Appeal Decision

Decision date: 14 February 2025

Appeal Ref: APP/Z4718/W/24/3356304

88 Shirley Road, Little Gomersal, West Yorkshire, BD19 4ND

Project: - 88 Shirley Road, Gomersal, BD19 4ND	
Title: - Proposed Plans,Elevations & Sections (New Dwelling)	
Scale: -	1:100
24/04/2024	MH

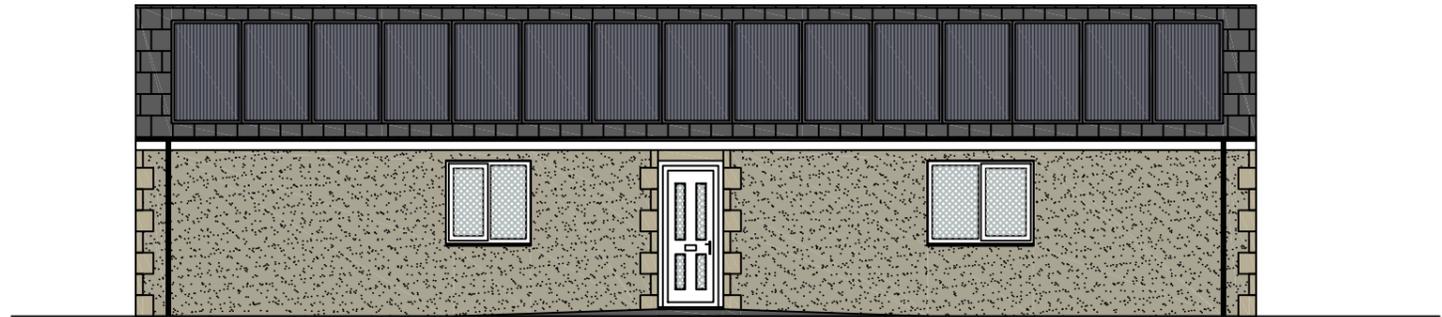
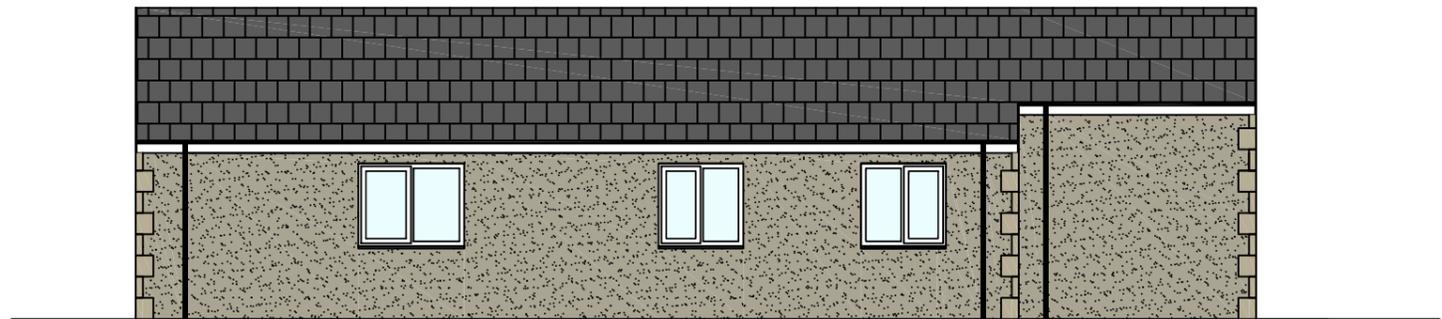
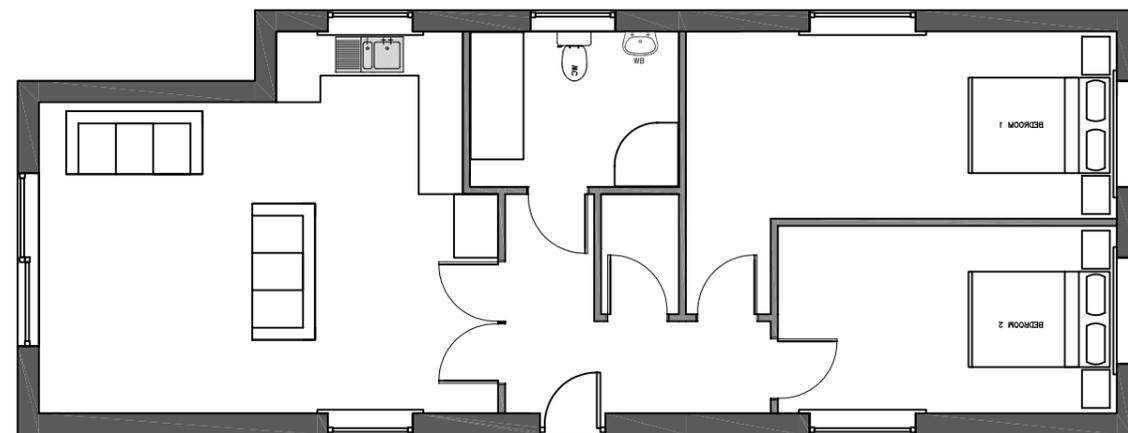
6. The contested element of the proposal is the construction of a small single storey dwelling in the side garden of the host property. In plan form it would broadly mirror the T shape of the existing building, and the eaves height would be very similar.

7. The proposal would take up a large amount of the existing garden area and would appear as a cramped development shoehorned onto the site. For this reason it would significantly diminish the generally wide spacing of properties along this part of Shirley Road, and harm the character of the streetscene. In coming to that view I am particularly conscious of the open space around the scout hut, and the fact that the proposal would visually encroach onto the open area.

8. The appellant has referenced a building line, including the scout hut itself, and the way in which the proposal would compare with the line. However, having visited the site I do not consider that there is a readily apparent building line in this part of the road. Even if there were the key issue is the spacing of properties rather than any notional building line.

11. For the reasons set out above the proposed single storey building would conflict with these policies and harm the streetscene.

| Title: - Tree Information Plan | |

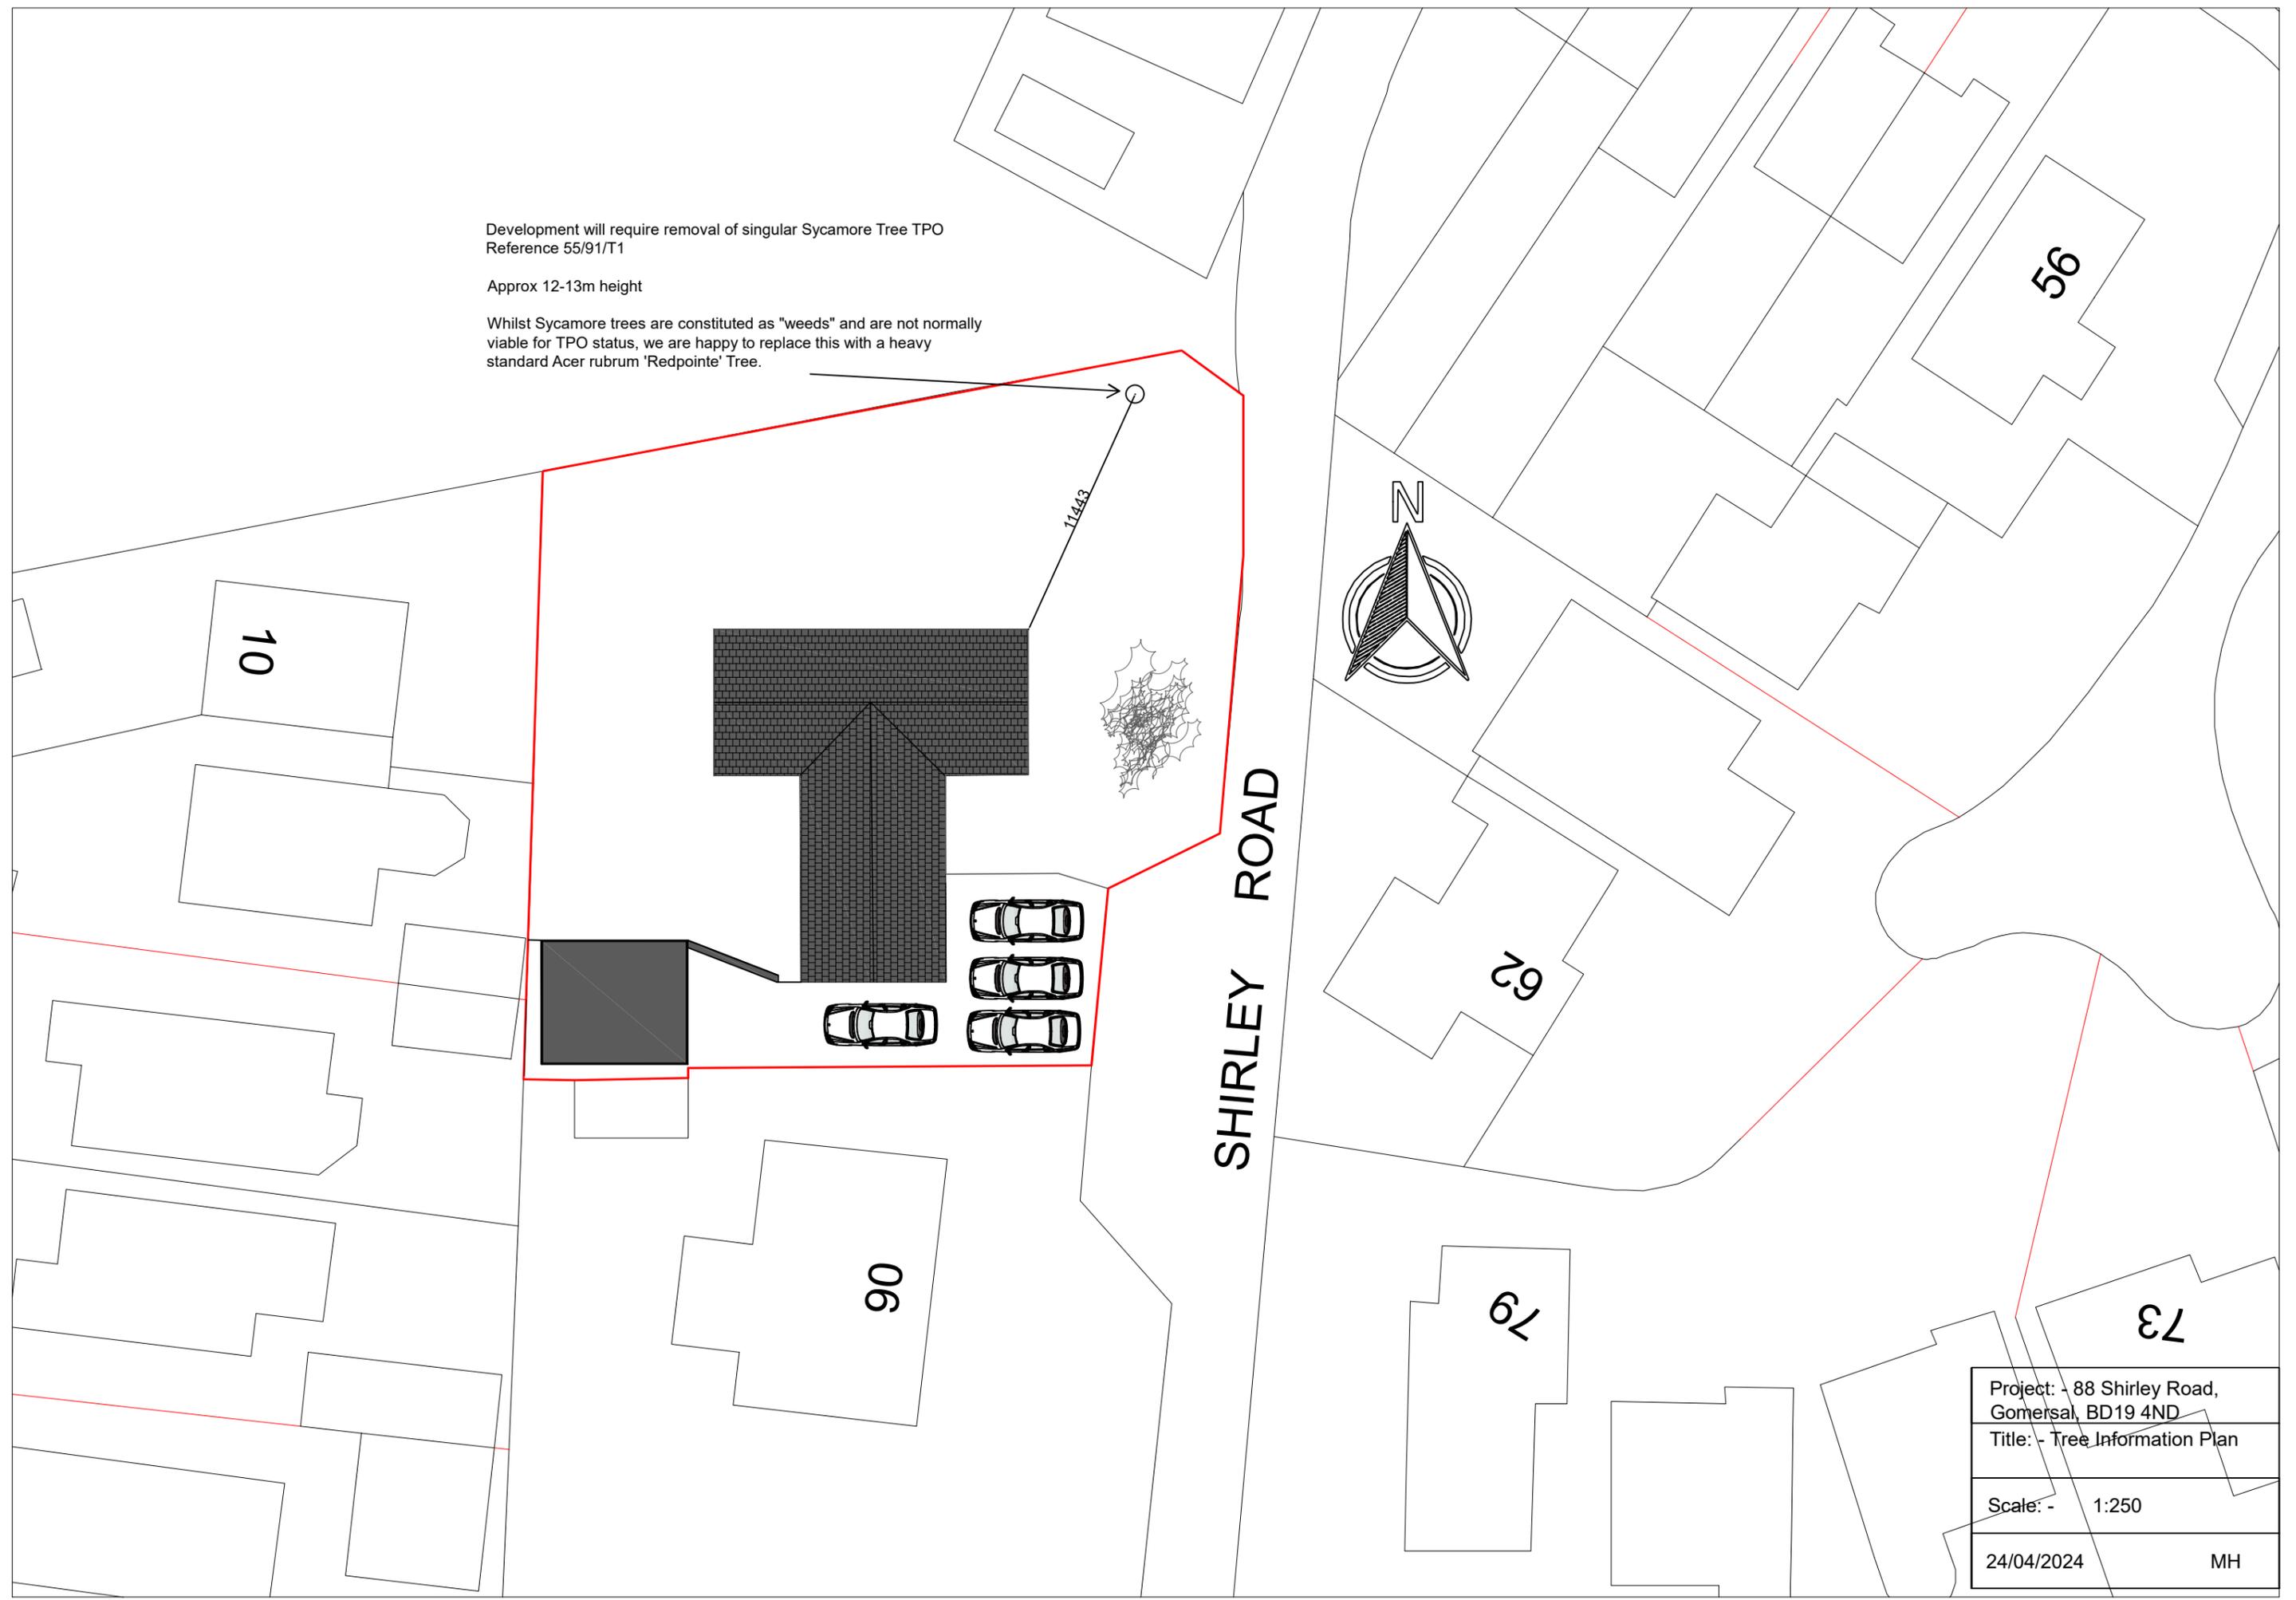
12. I obtained a clear view of the protected tree on my site visit. It is a mature sycamore close to the road, and I have no doubt that, especially when in leaf, it makes a substantial contribution to the area. Indeed the appellant refers to it being visually appealing.

13. If the tree remains in place the development could not go ahead. I am inclined to agree with the Council that the reason for the proposed felling is to enable the development to go ahead. The appellant has stated that it is causing damage to the existing house but, aside from one photograph at an uncertain point, this has not been supported by evidence.

14. I appreciate that the appellant has stated that the tree would be replaced by a smaller less invasive species. However this would be a very limited compensation for the loss of the existing tree.

15. With any application to fell a protected tree a balancing exercise needs to be undertaken. The need for the works applied for must be weighed against the resultant loss to the amenity of the area. In this case there is insufficient evidence to justify the removal of the protected tree and the removal would harm the character and appearance of the area. The proposal would therefore conflict with
